Ribble Valley Borough Council
By email

Your ref 3/2025/0758
Our ref DC/25/3087
Date 09-DEC-25

Location: Land off Whalley Road Hurst Green (adjacent to Reed Deep BB7 9QJ)
Proposal: Proposed change of use of agricultural land to four no.1 bedroom holiday lodges,

DRAWING REFERENCE: 2025-040-01

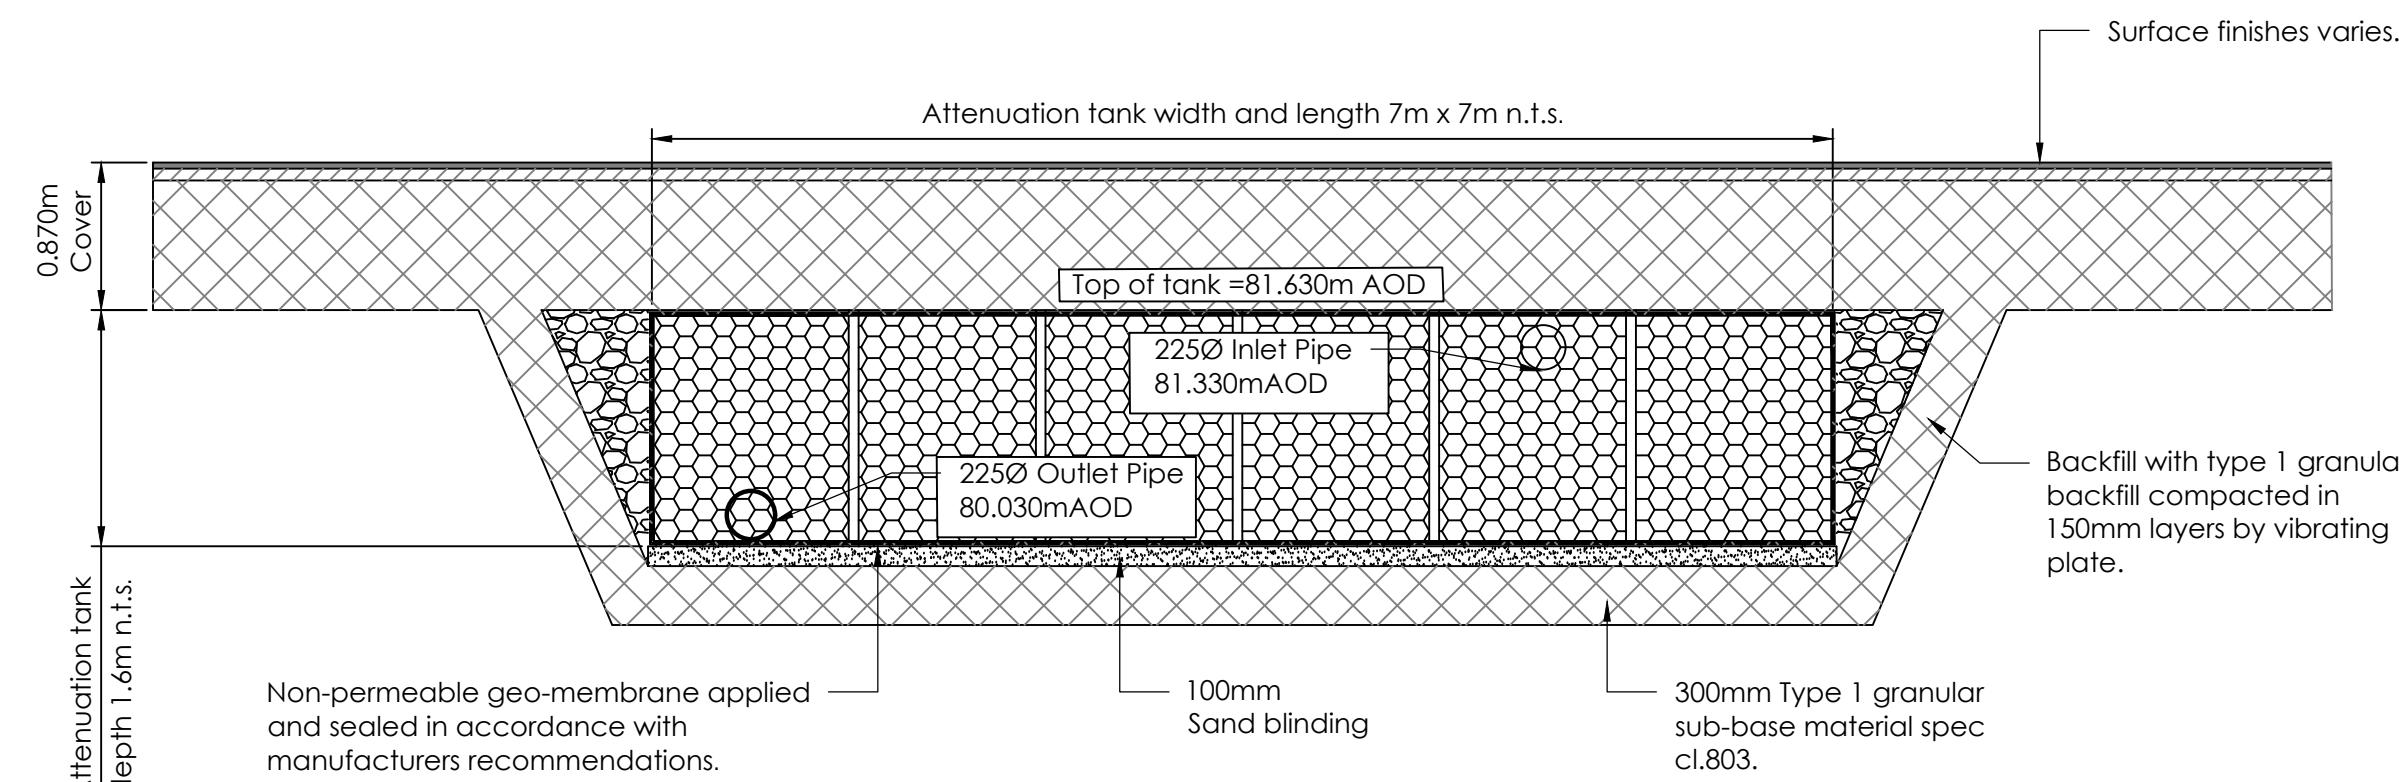
The drainage for the development hereby approved, shall be carried out in accordance with principles set out in the submitted Foul & Surface Water Drainage Design Drawing 2025-040-

01, - Dated 13/06/2025 which was prepared by Flood Risk and Drainage Solutions Ltd. For the avoidance of doubt surface water must drain at the restricted rate of 2 l/s. No surface water will be permitted to drain directly or indirectly into the public sewer. Prior to occupation of the proposed development, the drainage schemes shall be completed in accordance with the approved details and retained thereafter for the lifetime of the development.
